From: [Patti Hebert](#)
To: [Jeremiah Cromie](#)
Subject: RE: VA-23-00003 Sparks Variance
Date: Wednesday, May 10, 2023 10:58:00 AM

RE: VA-23-00003 Sparks Variance

I am writing to express my strong opposition to the proposed zoning variance set out in application VA-23-00003, Sparks Park Variance. I am very against this application, and the following are my major concerns:

PRELIMINARY SITE PLAN
 MOUNTVIEW GROUP LLC TRAVEL CENTER
 WEST SPARKS ROAD
 EASTON, WASHINGTON

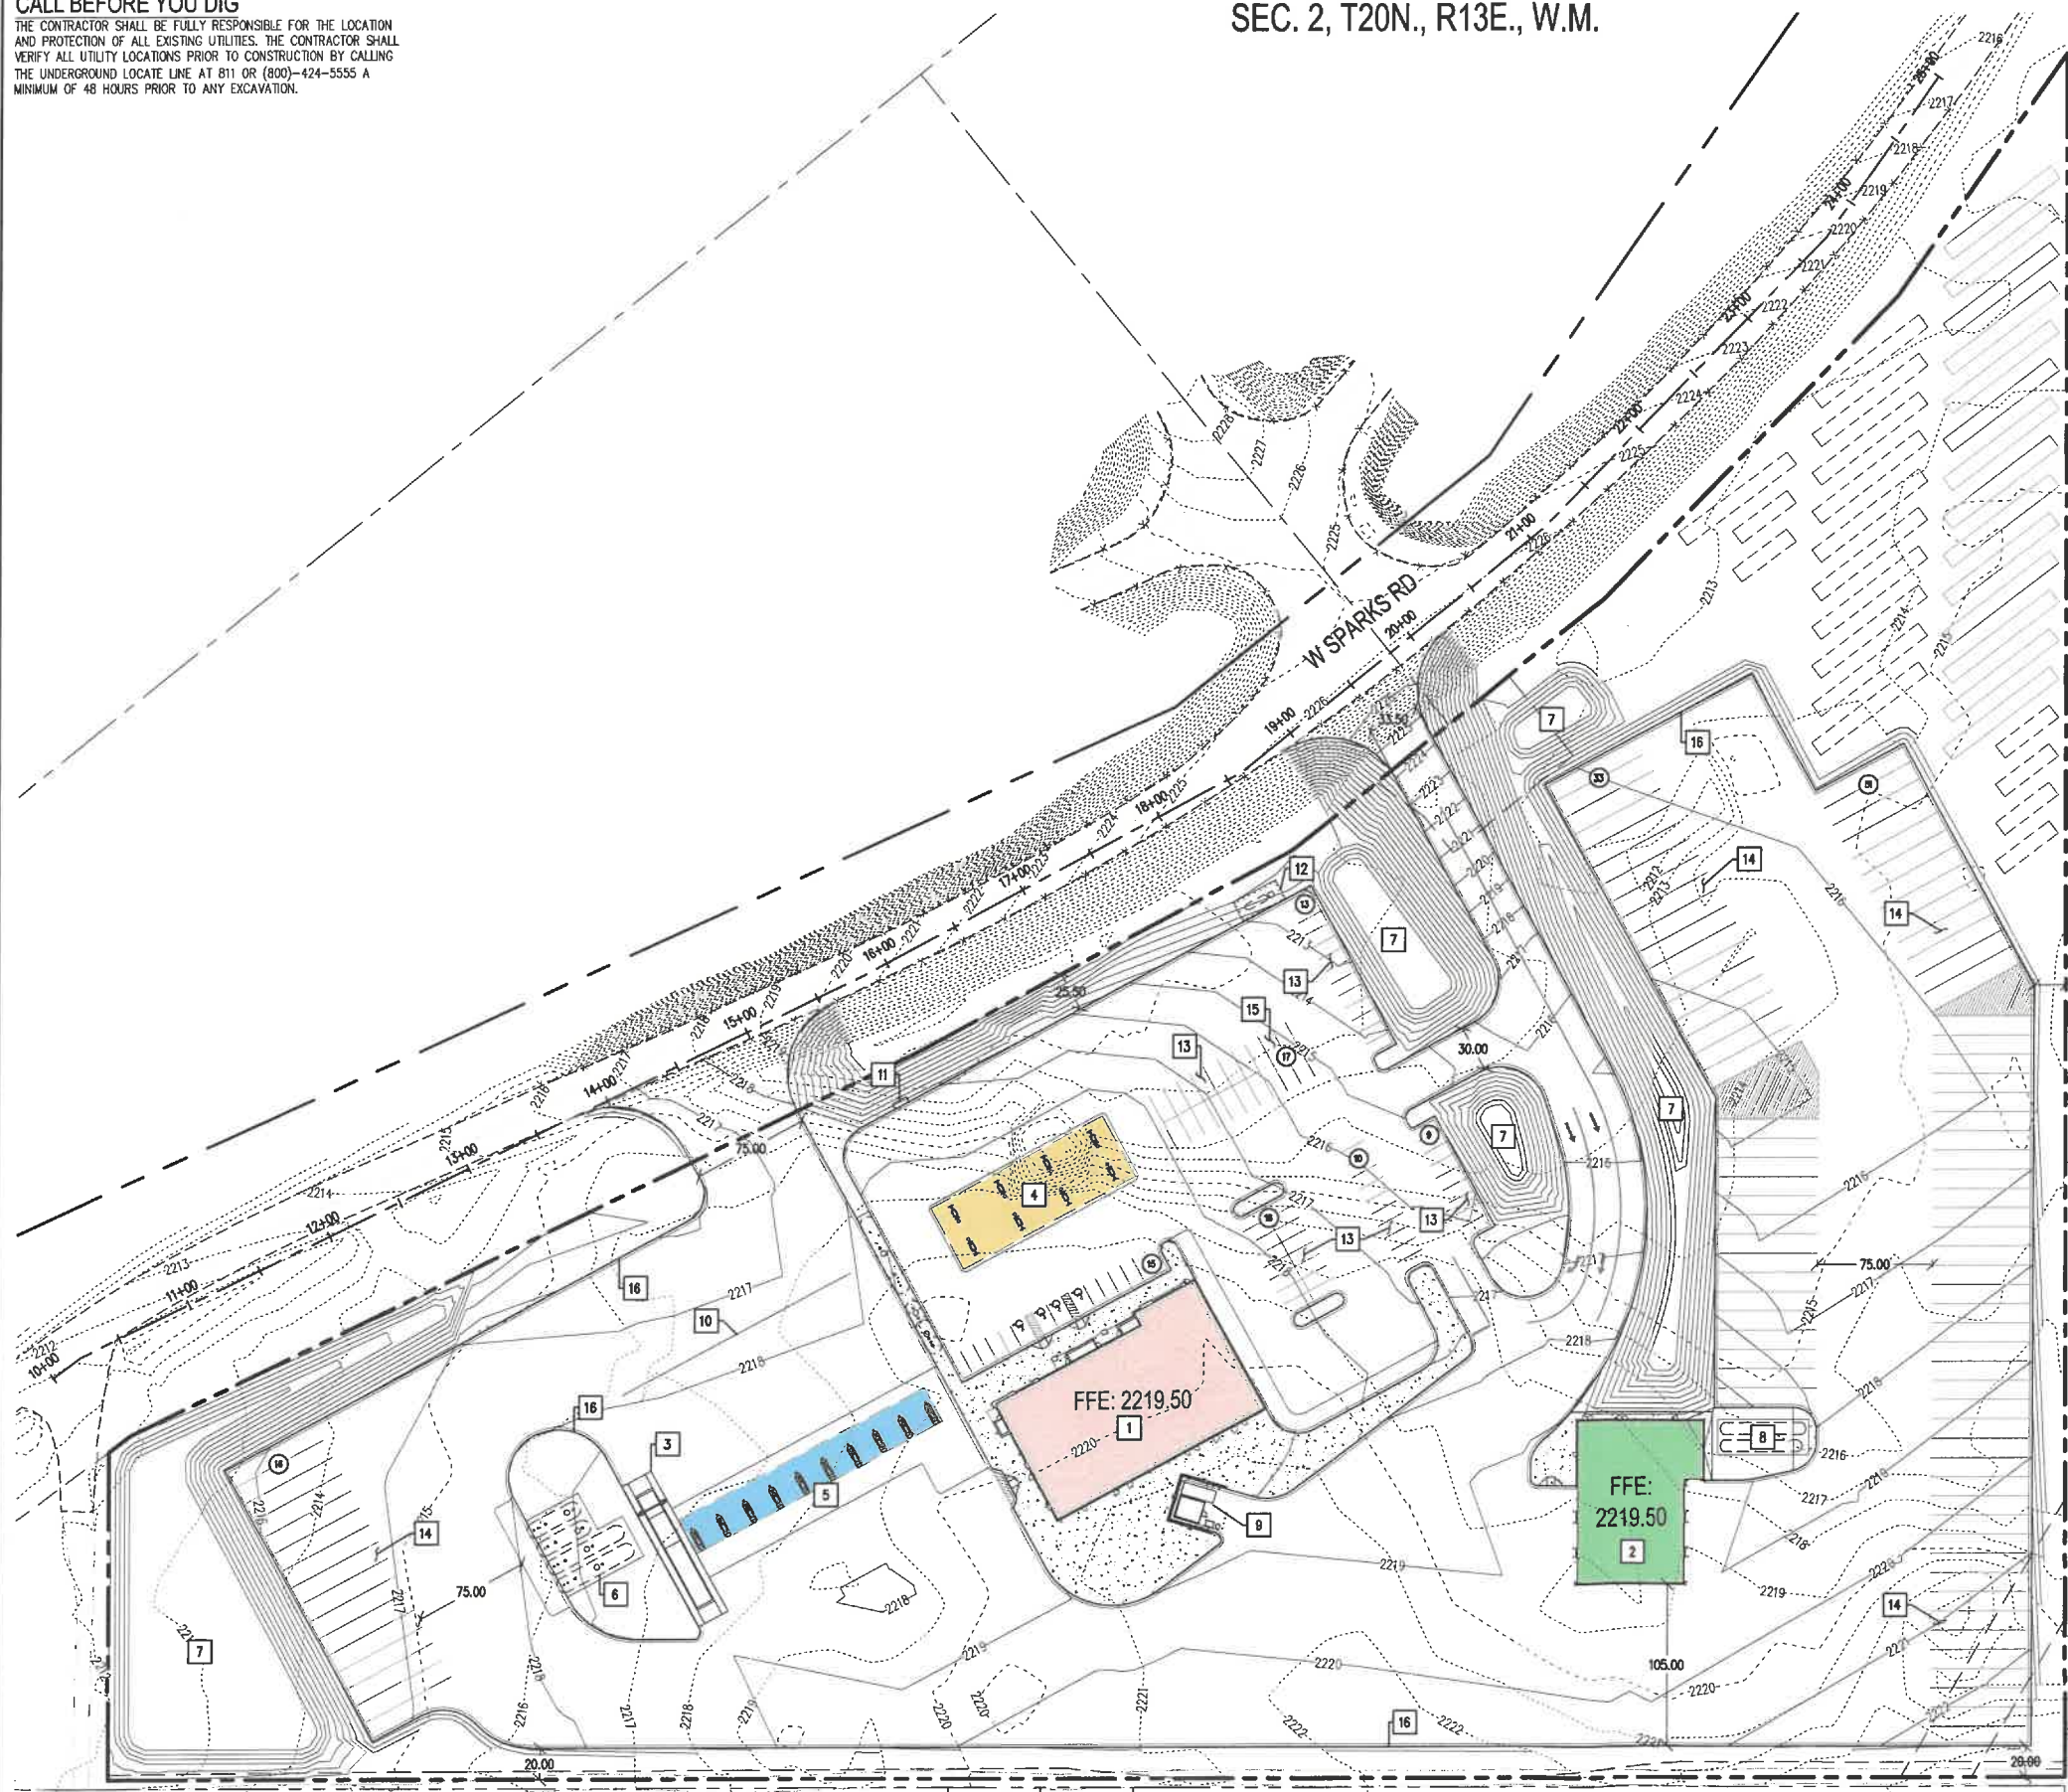
(2)The removal of all trees in the project area which lays within a watershed that supplies drinking and irrigation water, is insensitive to that fact that fresh water begins in healthy forests. To allow septic tanks, storm and surface water (laden with fuel, oil, antifreeze, de-icing materials) to be discharged into ground water under the truck site, it

follows that this also would go into Kachess river and lake Easton -1/4 mile from the proposed site.

There are no sufficient prescribed remedies to this concern in the application.

There is NO snow removal plan included or identification of snow storage location identified. The application seems to ignore the heavy snow loads and adverse weather effects on the location, and does not provide sufficient remediation.
